From: Devin Marshall <devin@oggimojo.com>
Sent: Friday, April 17, 2026 5:21 PM
To: Ellie Myers
Subject: PUD project on Kittitas Highway

A1.0

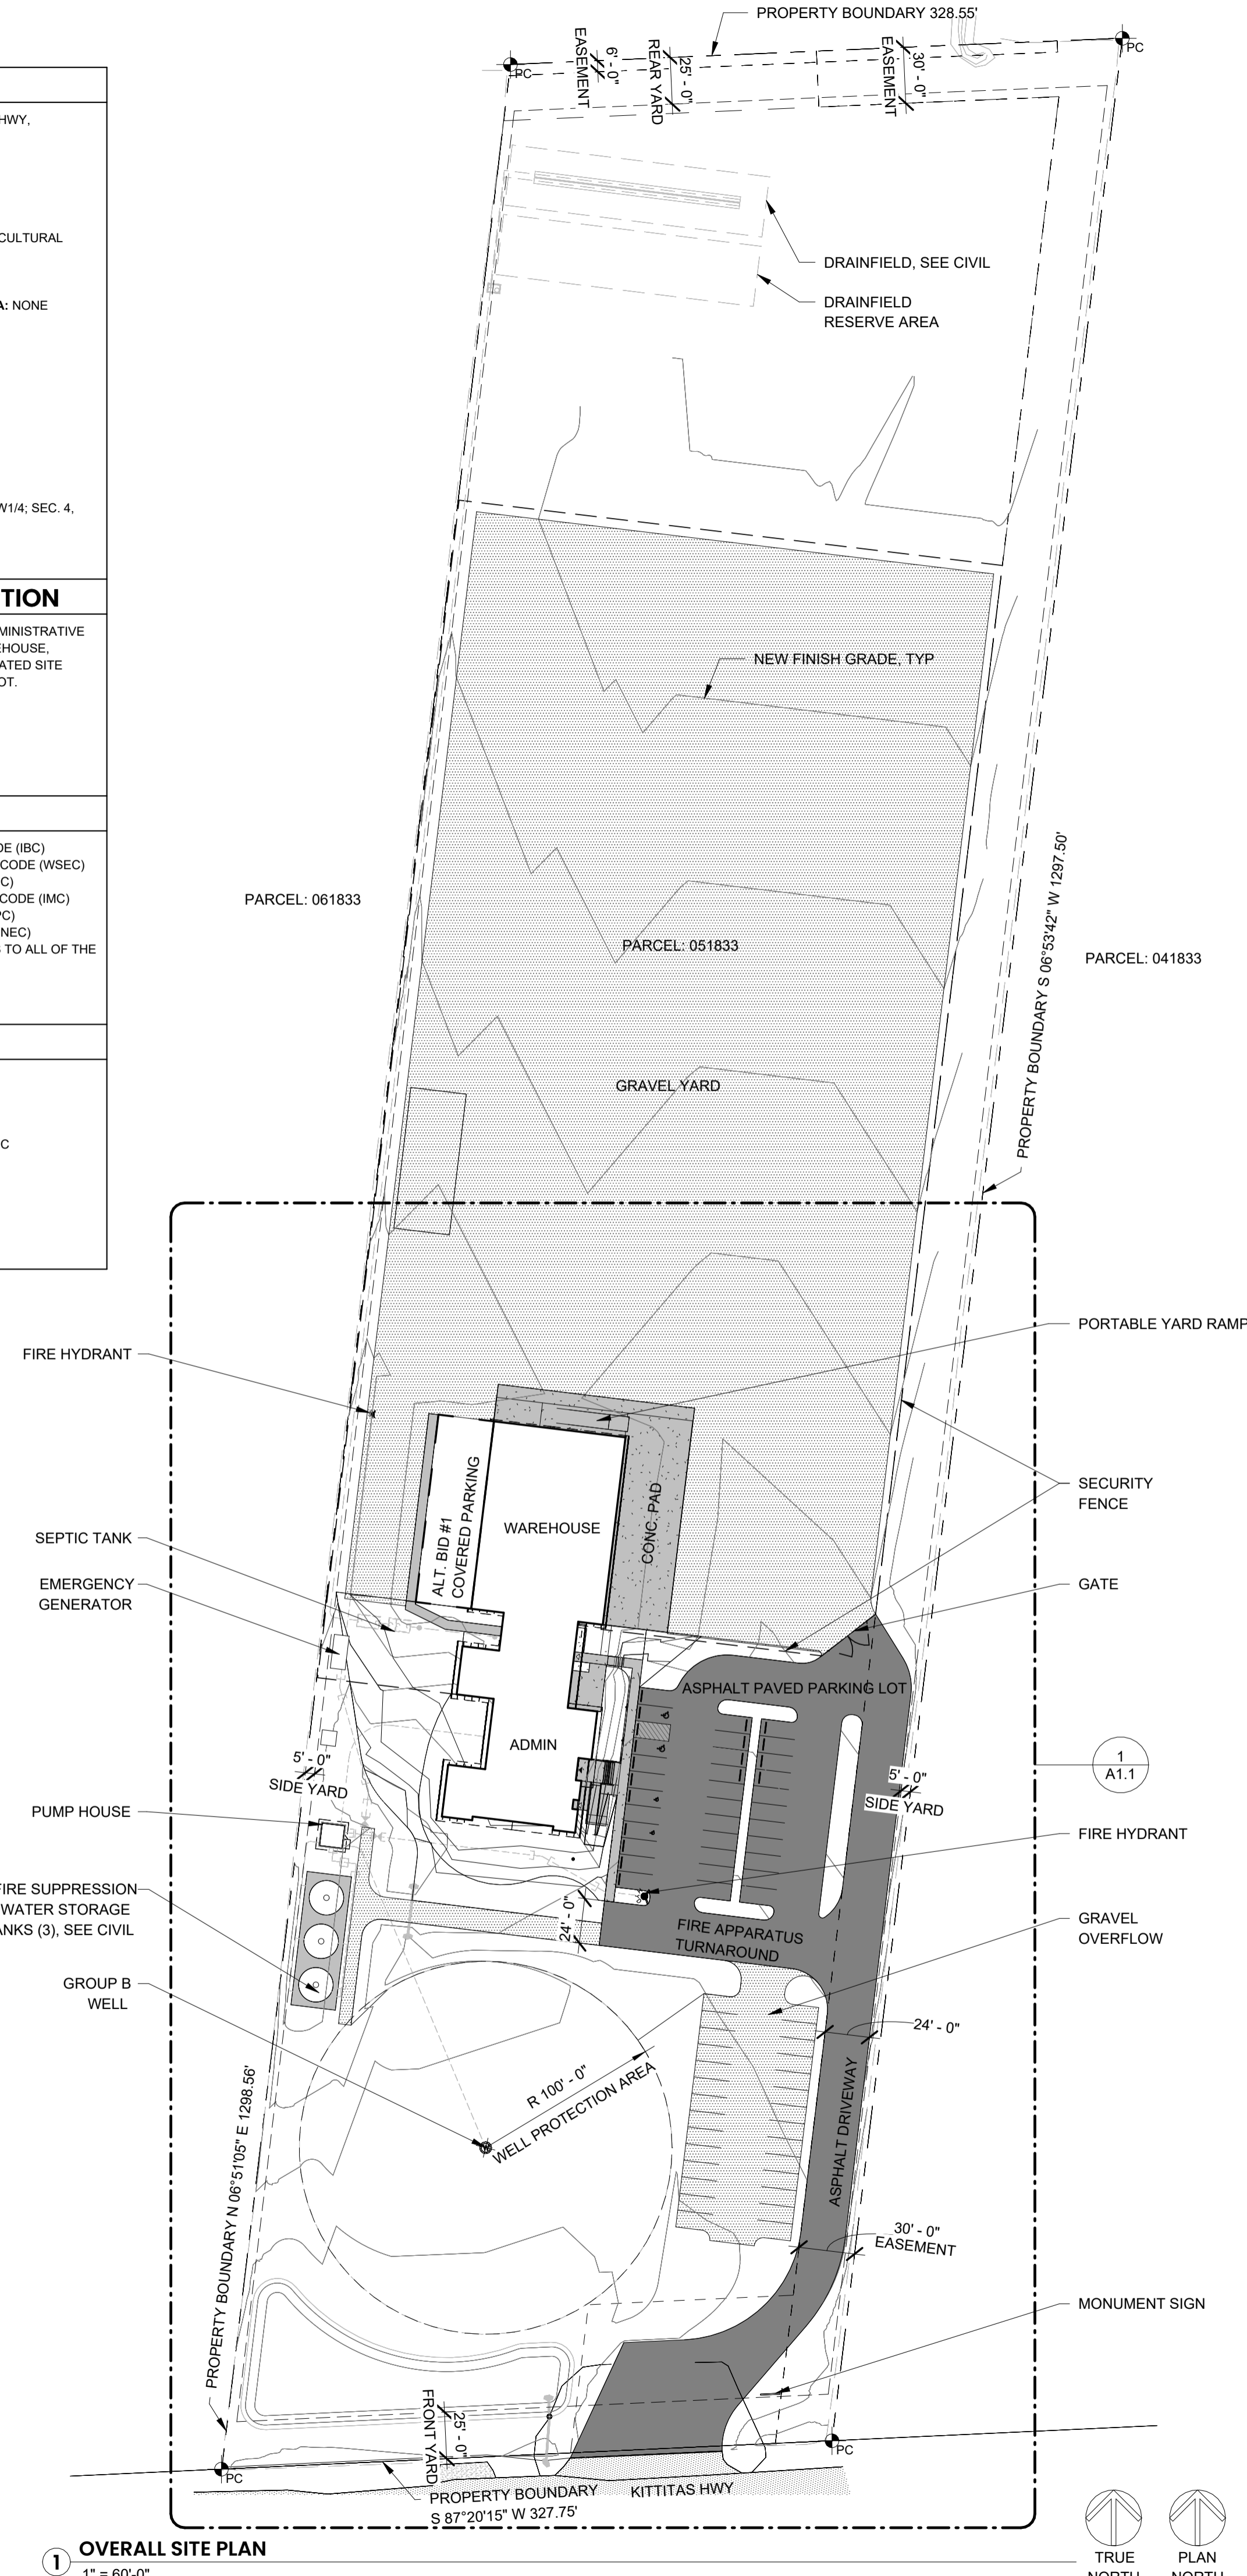
Right next to your planned drain field area on our property is a collection pond that helps manage flooding from the surrounding fields—especially during the planting season, when the land becomes waterlogged. If this isn't already on your radar, I'd encourage you to consider it in your planning, as it's been essential in keeping our property and the neighboring fields protected.

Another area to be mindful of is where your office building is planned to sit. The meeting point of our lots, including our driveway, regularly floods when the farmland is irrigated. Our driveway has sometimes been underwater for over a month. Last year, when your land wasn't farmed, we noticed less flooding, but it still occurred. My hope is that your project can help address or at least not worsen these ongoing issues.

I'm especially concerned that changes to your property—like filling in building foundations—might inadvertently divert even more water toward our driveway or increase drainage challenges for all of us on this side. I share these details not just for our own peace of mind, but because I believe we all want to be good neighbors and find solutions together.
